# SEA LINK

EN020026

## Comments on Submissions received by Deadline 5

Suffolk County Council

Creator: DF	Date: 06/03/2026	Checker: EB	Date: 06/03/2026	Approver: JS	Date: 06/03/2026
Document Ref: FIGURE 2F	Scale: 1:5,000	Format: A3	Sheets: 1	Rev: 0

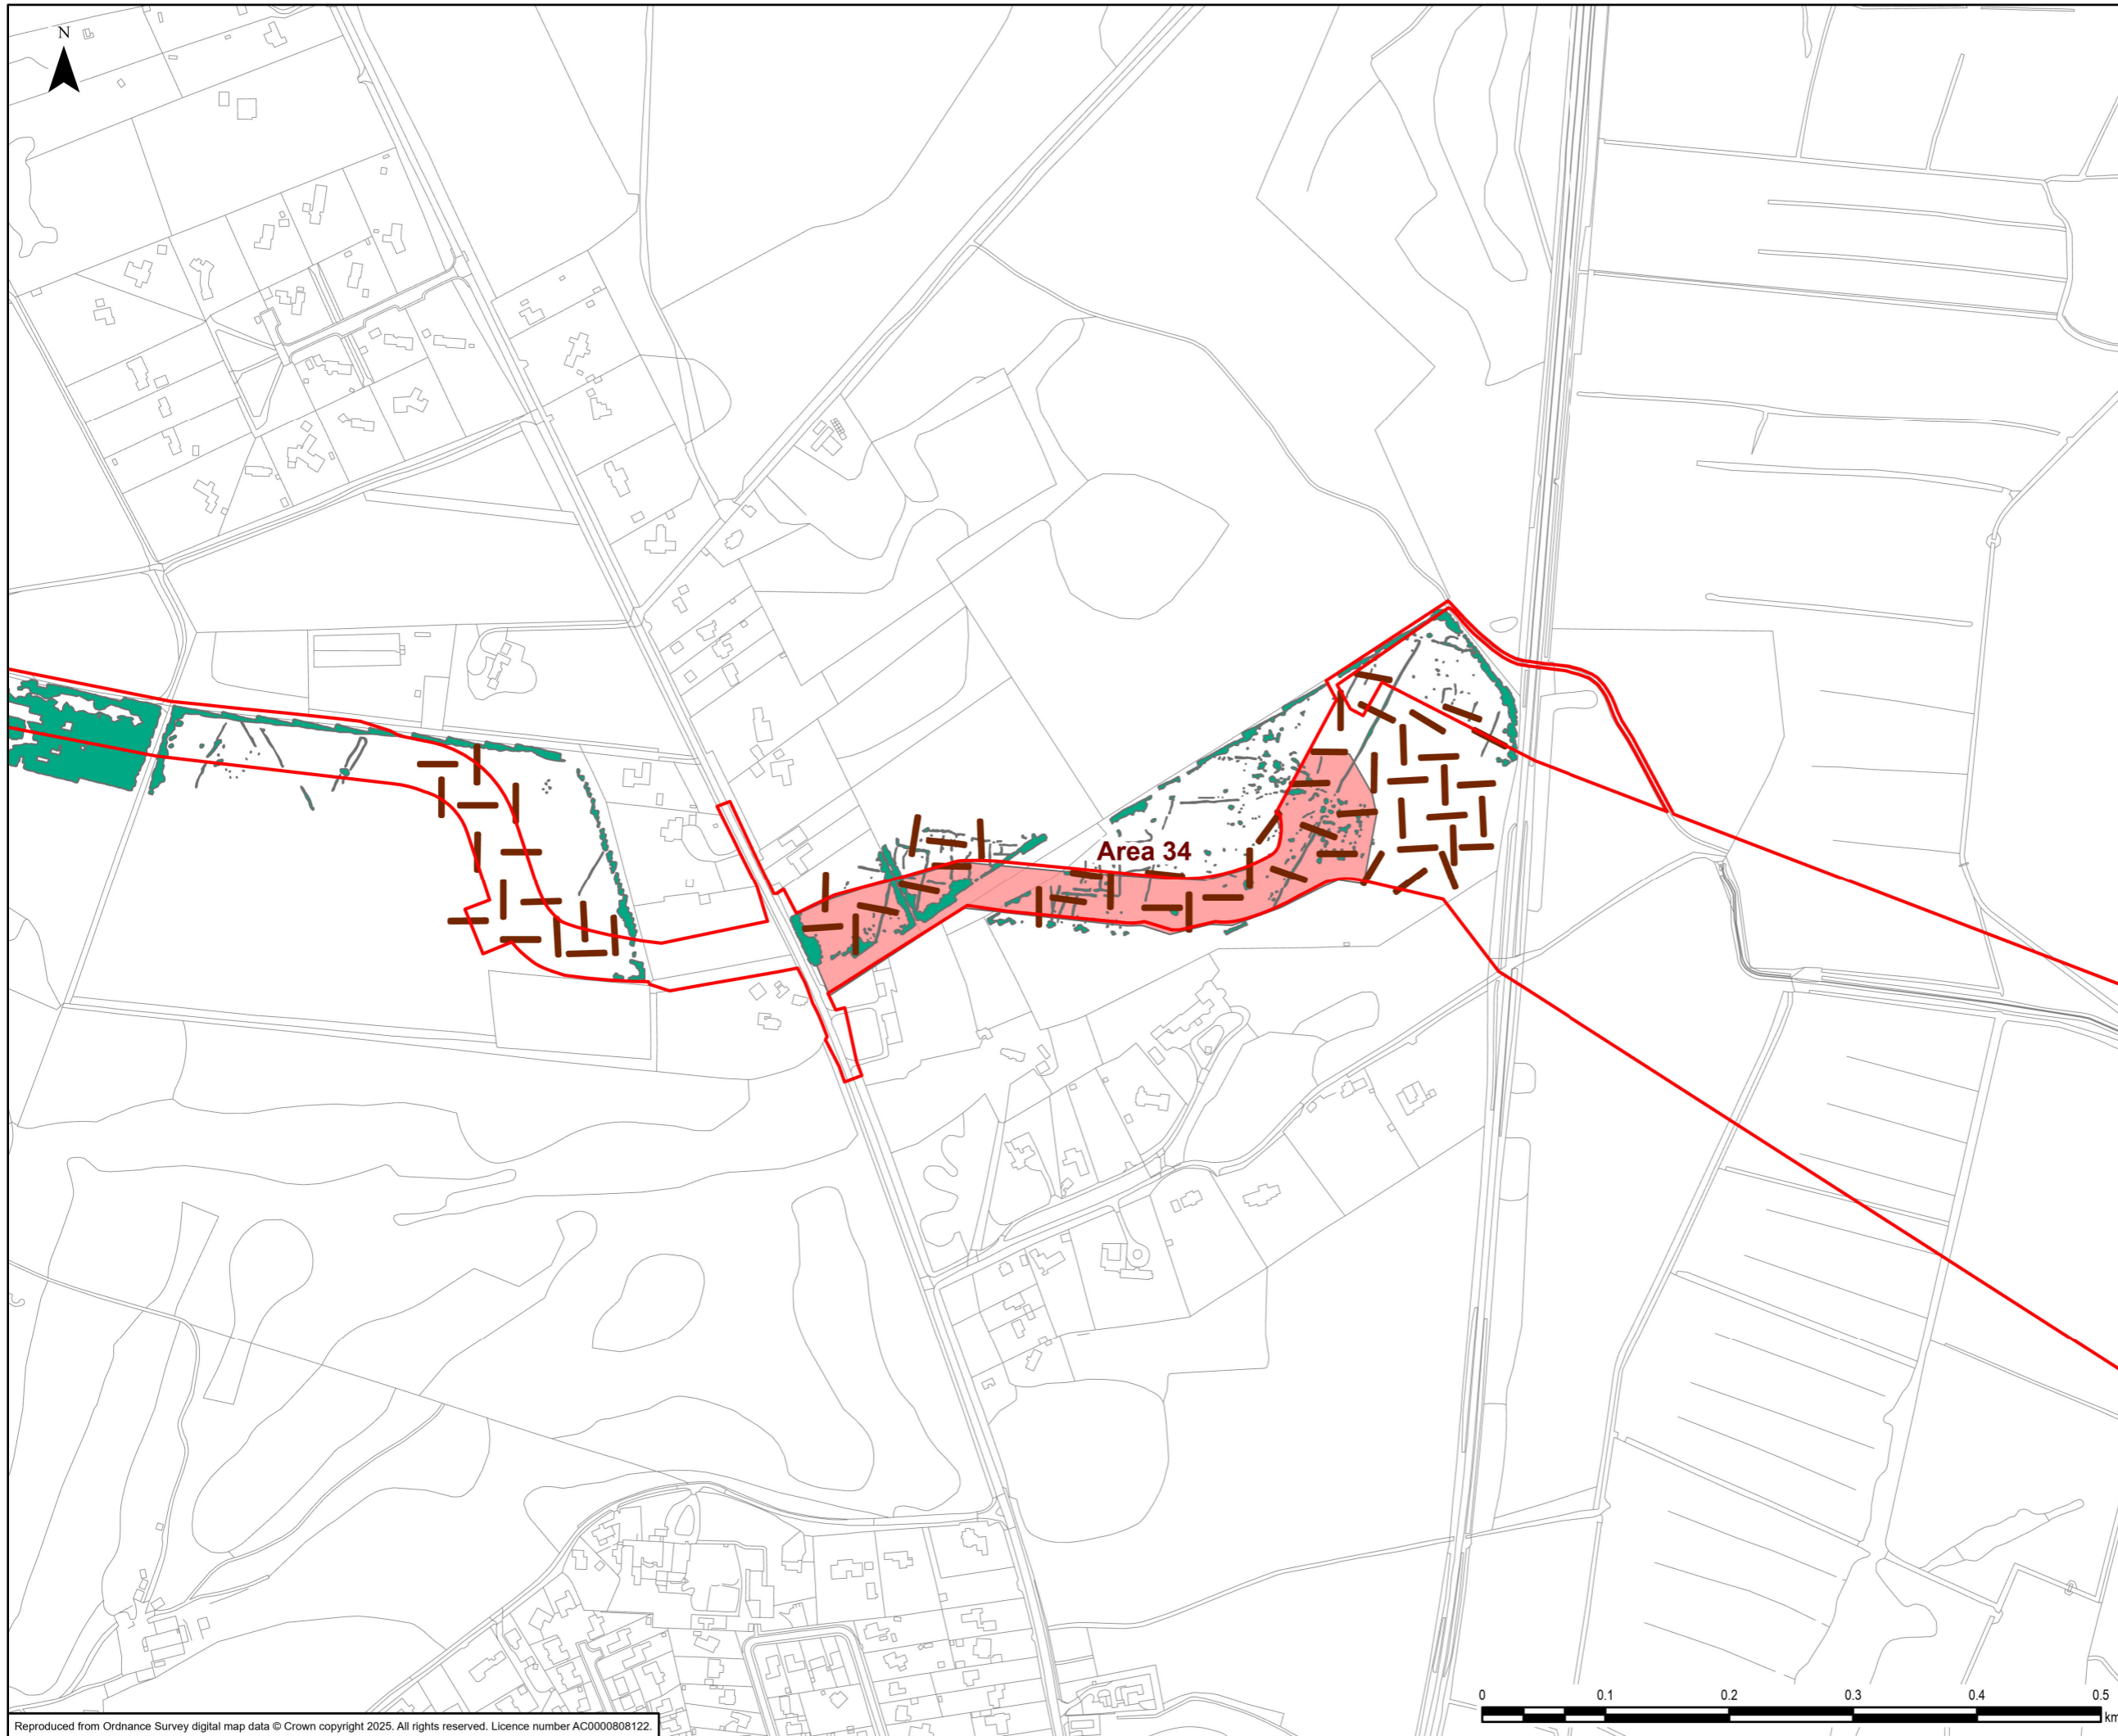
4)		Mitigation areas/scope	<p>1.3.4 SCCAS have provided detailed comments regarding mitigation areas and the scope of the ongoing evaluation and mitigation work which is required for the project to the Applicant’s archaeological consultant. As such, Appendix A is not currently approved as not all mitigation areas are yet agreed and as an up to date and clearer plan showing the evaluation status for different areas of the scheme is needed.</p> <p>However, SCCAS would advise that as the final scope of evaluation and mitigation work will be agreed within the site specific WSIs, that plans showing provisional mitigation areas should be omitted from the OWSI as it is a working document and likely to change.</p> <p>SCCAS would advise that what is required in the OWSI is an up to date plan showing the status of evaluation works for the entire onshore area of scheme in Suffolk and clearly identifying which land parcels have had evaluation works</p>

Ref. No	Topic	Summary of submission	SCC Response
			completed and those where evaluation/assessment is still pending, based upon the latest order limits and works plans.
